From: [Candice Comfort](#)
To: [Chace Pedersen](#)
Subject: Opposition to the Atlas Cellular Tower Project
Date: Tuesday, August 22, 2023 9:27:02 PM

In the middle of August, I learned that Kittitas County had received an application from Atlas Tower 1 LLC to build a 100ft tall cell phone tower off Manastash Road at Blazing Sky Lane on the rural property of Victor Strand that is zoned as residential. As my family lives very near this location, I have a deep investment in this project for multiple reasons, and am writing to express my opposition to this tower.

Z-3

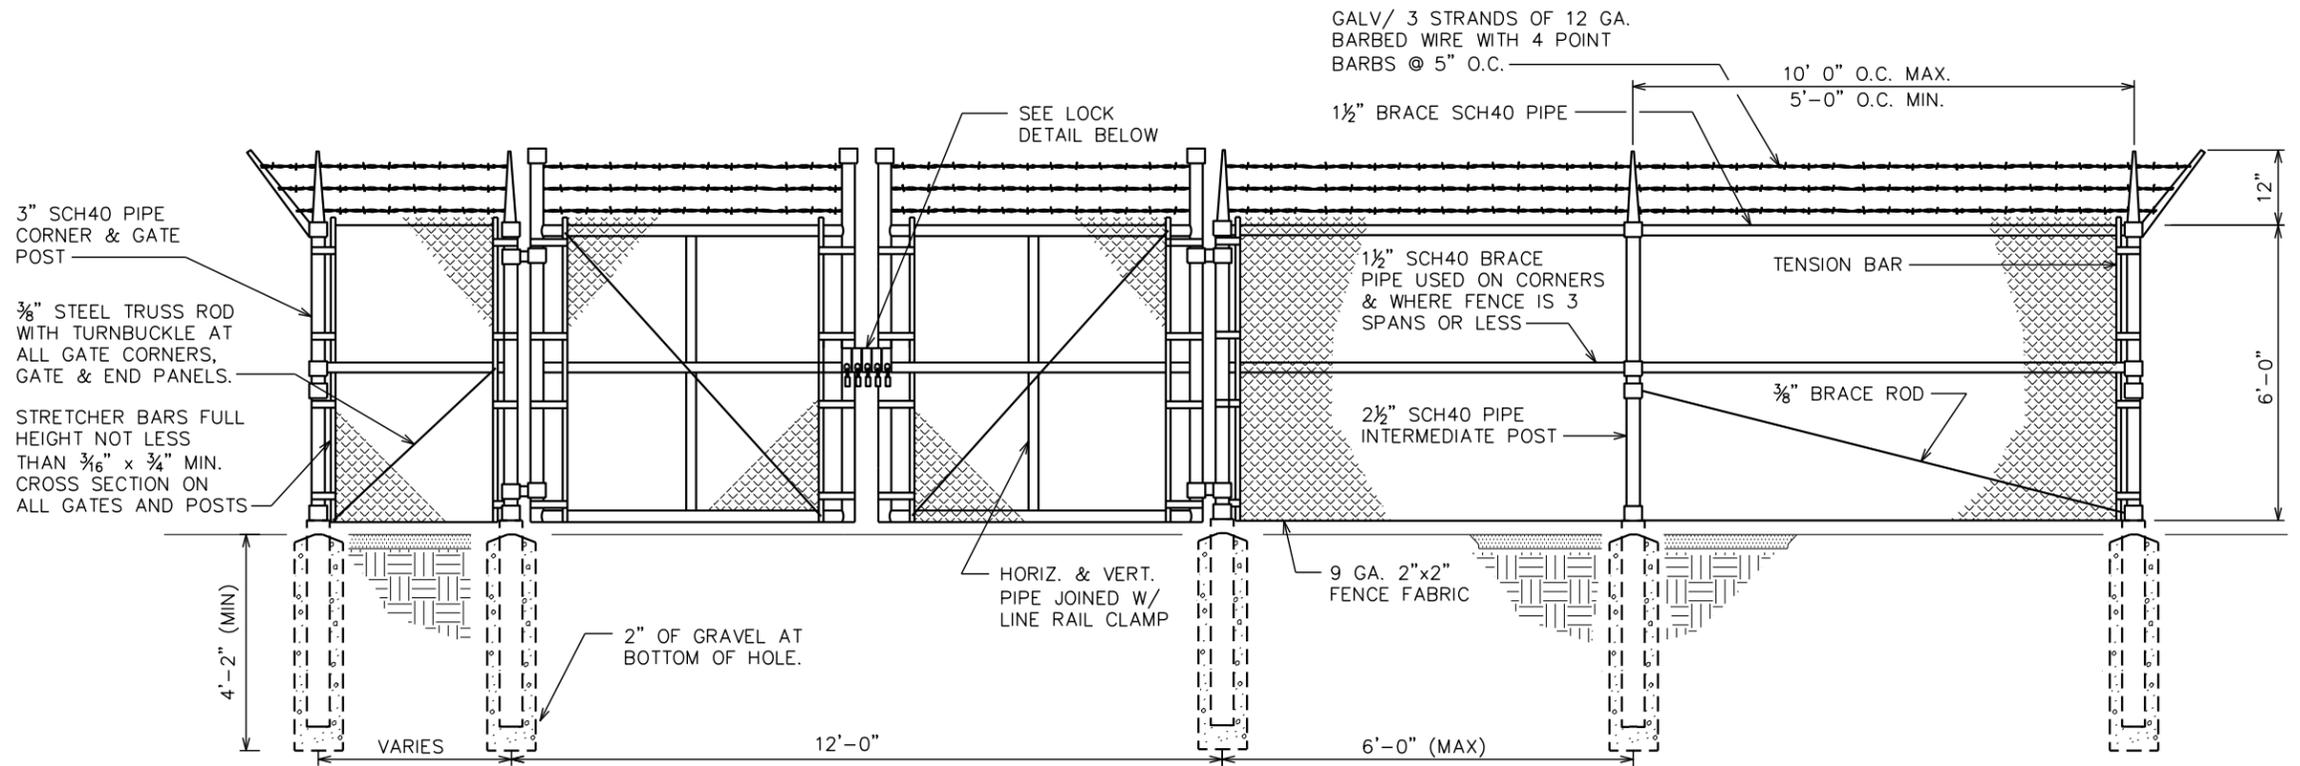
While reading Atlas' site plan on page Z-3, it shows the cell tower to remain a galvanized color unless directed otherwise by Kittitas County. If they were true to their word about maximizing visual aesthetics, they would understand that galvanized is in keeping with an industrial or commercial area, not the rural country. A company that is invested in doing its best for the community would know that ours is one of natural tones- tans or light browns for example. When one looks at Manastash Ridge, it is easy to see a hardened steel color would not blend in, but care to learn this was not taken. They also state in their site plan on page Z-4 that the 50'x50' fence they plan to construct around the tower and electrical facilities at the bottom will be chain link coated in black vinyl. Again, this is in keeping with an industrial or commercial area, not one found in an area blanketed by farmland and family homesteads. Out of any color that could be chosen, black is possibly one of the worst. As anyone who lives out

here knows, black things get covered in dirt and dust that is blown in our famous Ellensburg winds, leaving them sticking out like a sore thumb once they are coated in it. A brown or tan would much better hide the dirt that comes with rural lands and farming, and better yet, wood reinforced with steel poles on the back side where the public can't see them. It is easy to look around our area and view beautiful wooden barns that grace our rural landscape, but not black vinyl coated chain link fencing. If there is any attempt to keep the area rural and visually appealing, Atlas should know this and would have selected wood.
